Your ref: SSD 5041 Mod 1  
File no: MC-11-2620

Department of Planning & Environment  
GPO Box 39  
SYDNEY NSW 2001

**Re: SSD 5041 Mod 1 Section 96(1A) Modification Application for the Kings  
Park Metal Recovery, Processing and Recycling Facility**

STREETVIEW ELEVATION  
TATTERSALL RD

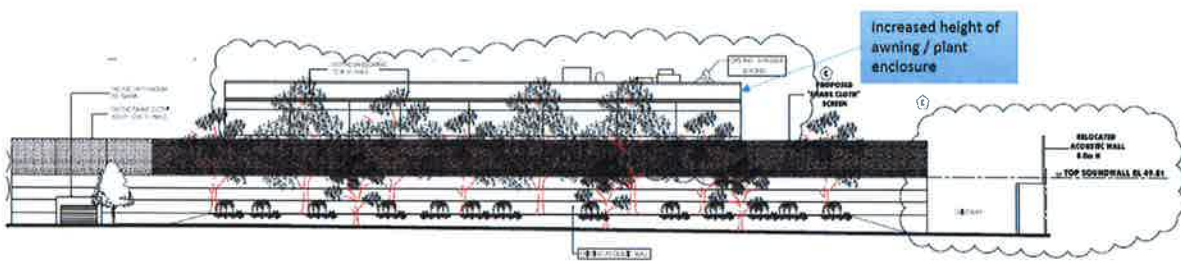
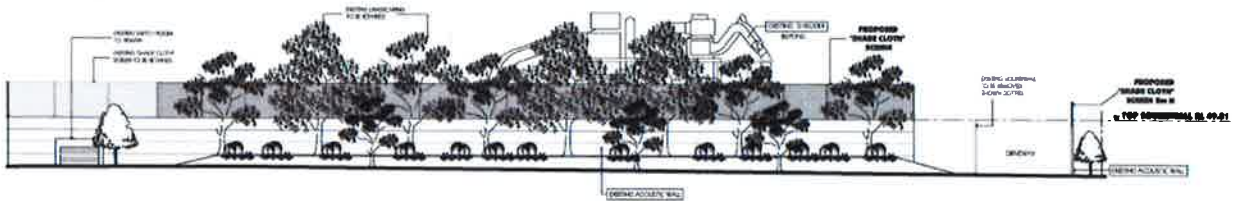
1. The actual height of the roofline of the proposed enclosure over the existing plant. The proposal indicates that it is "taller than 10 metres," however the actual building height is to be provided.

2. Details of the external finishes and treatments of the proposed enclosure and acoustic walls to ensure that the development, as viewed from the public domain (from Tattersall Road) does not present as a blank wall. The development is required to comprise methods to assist with breaking up the bulk and scale of this structure, such as different coloured banding on the elevation / wall.

Scale: 1:500 @ A1
Job Number:
Drawing Number:
Issue:

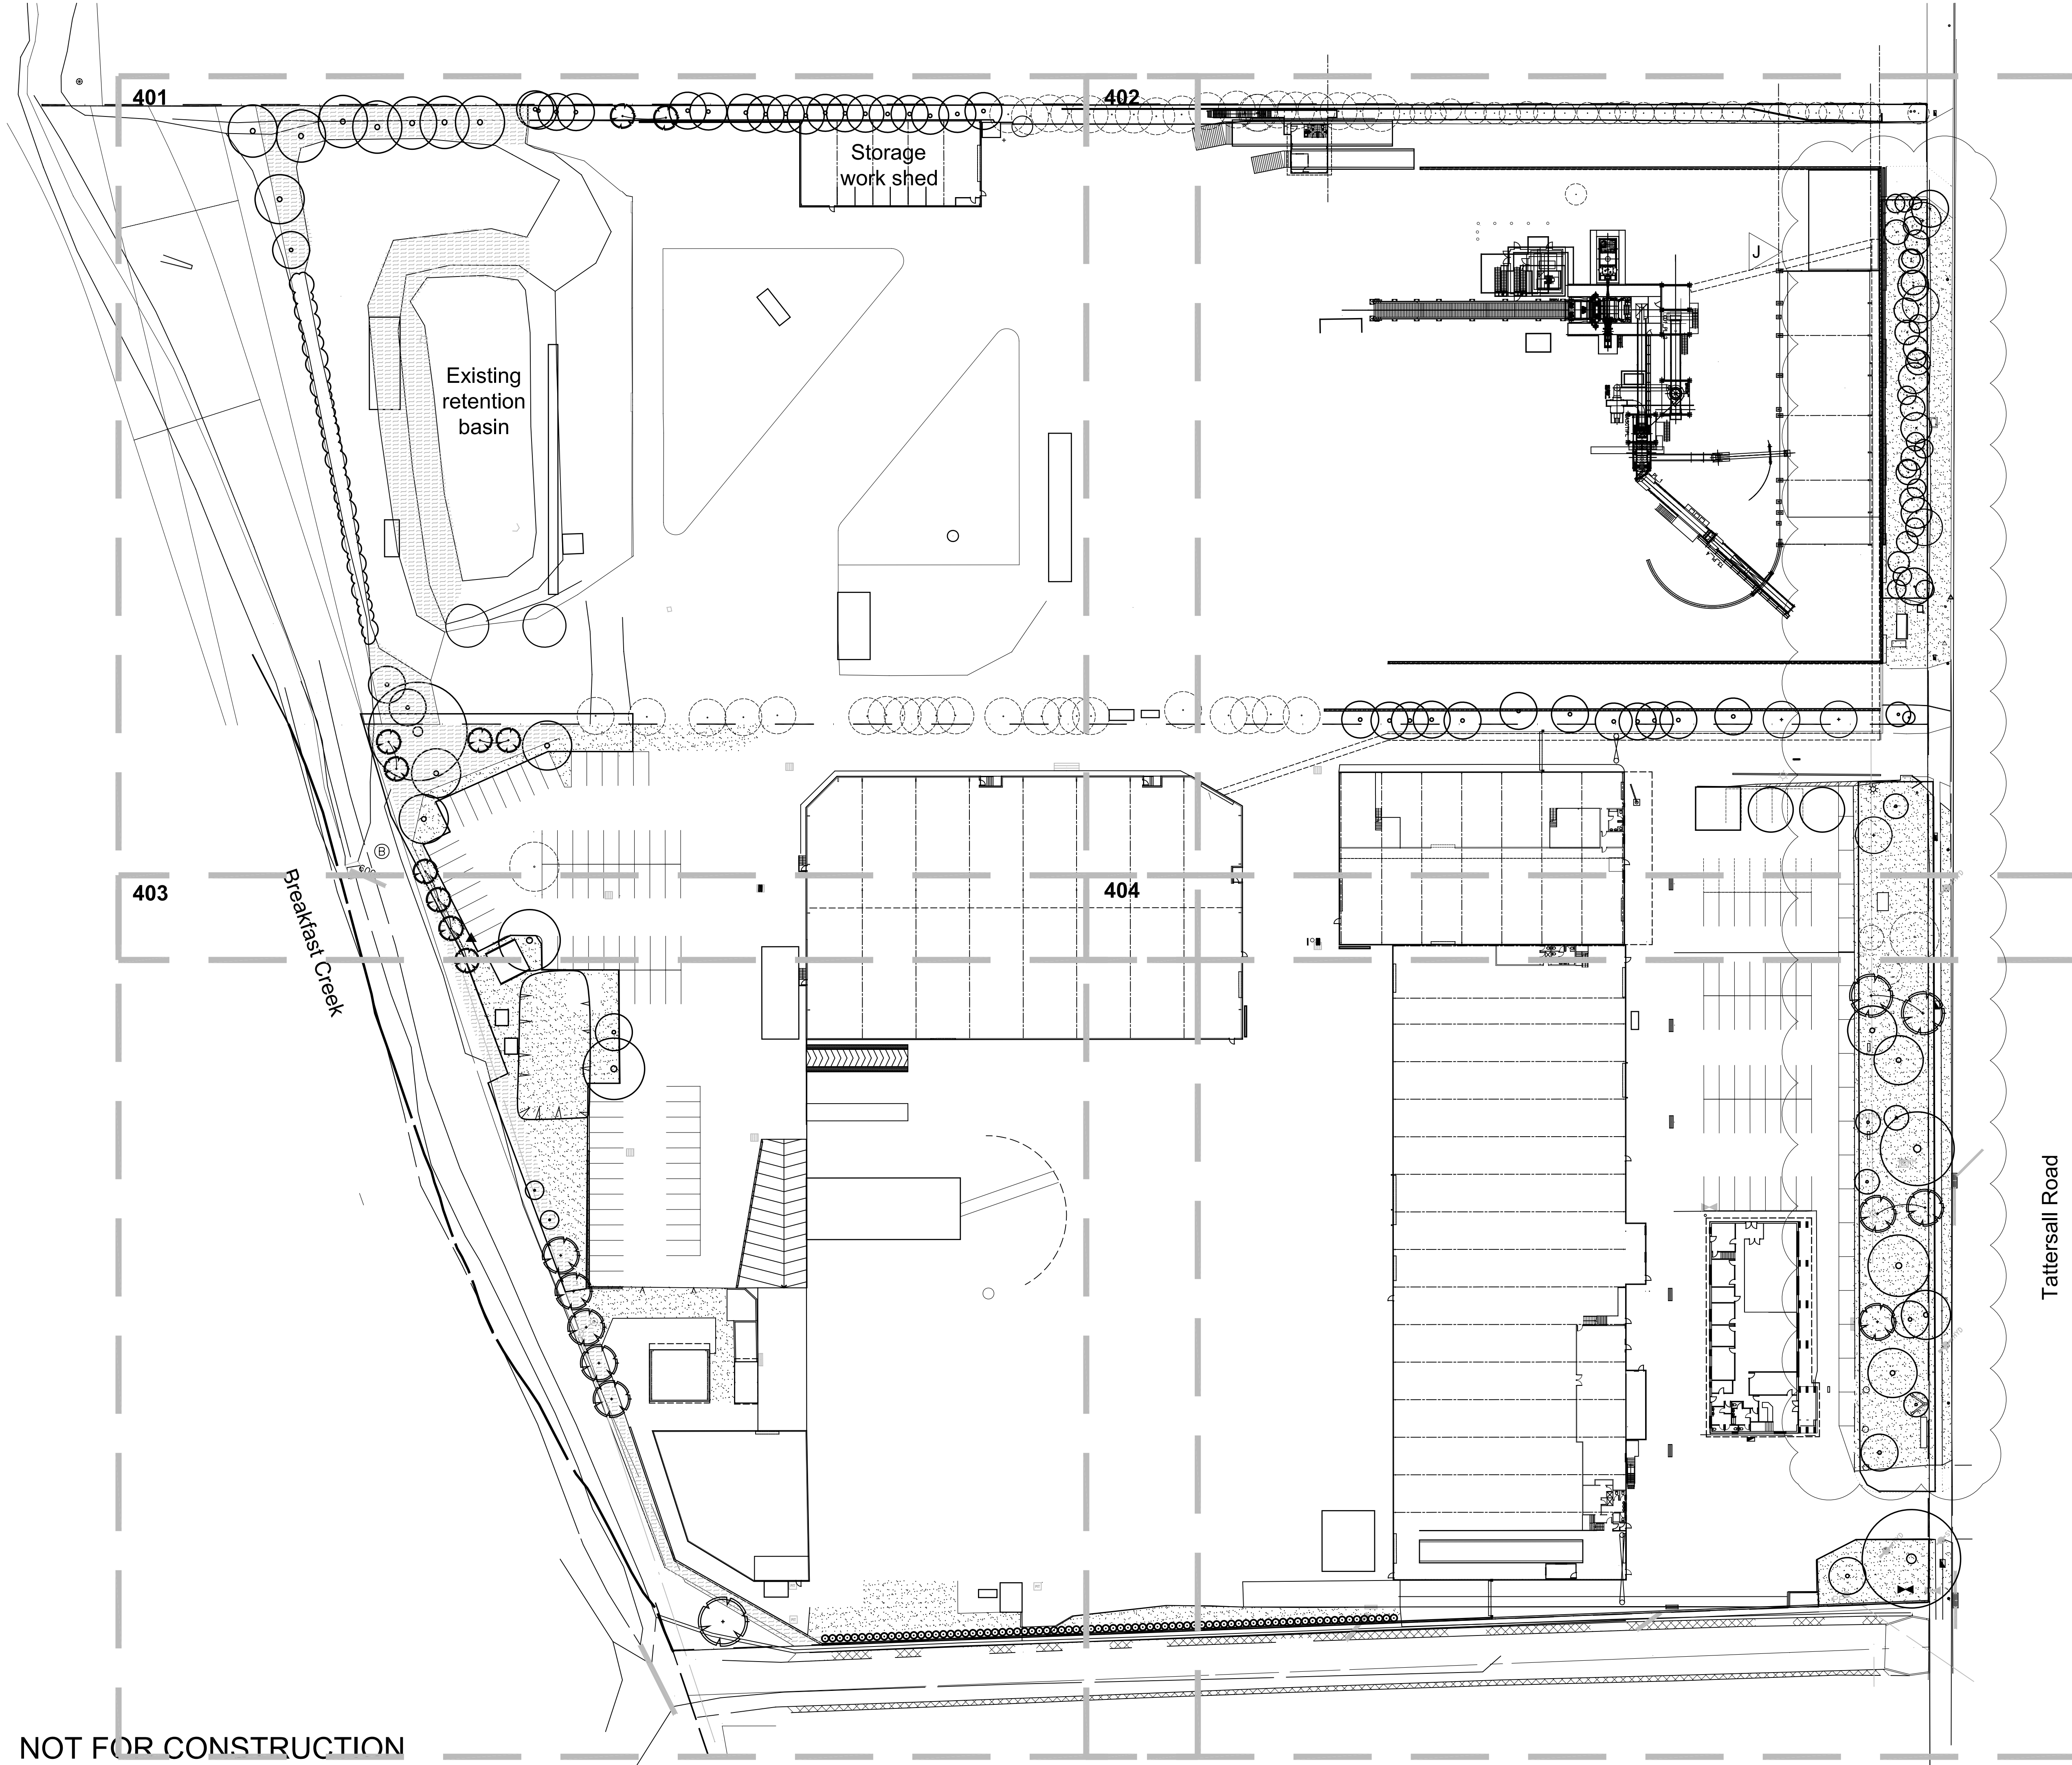
3. The application advises that the Applicant is liaising with the Department of Planning and Environment with regard to Condition B39 Landscaping. Please confirm that the Landscape Management Plan the subject of this condition specifically addresses the protection of existing trees along the street frontage in the vicinity of the proposed enclosure, and that appropriate additional planting is to

be provided to assist with ameliorating the bulk and scale of this structure as viewed from Tattersall Road.
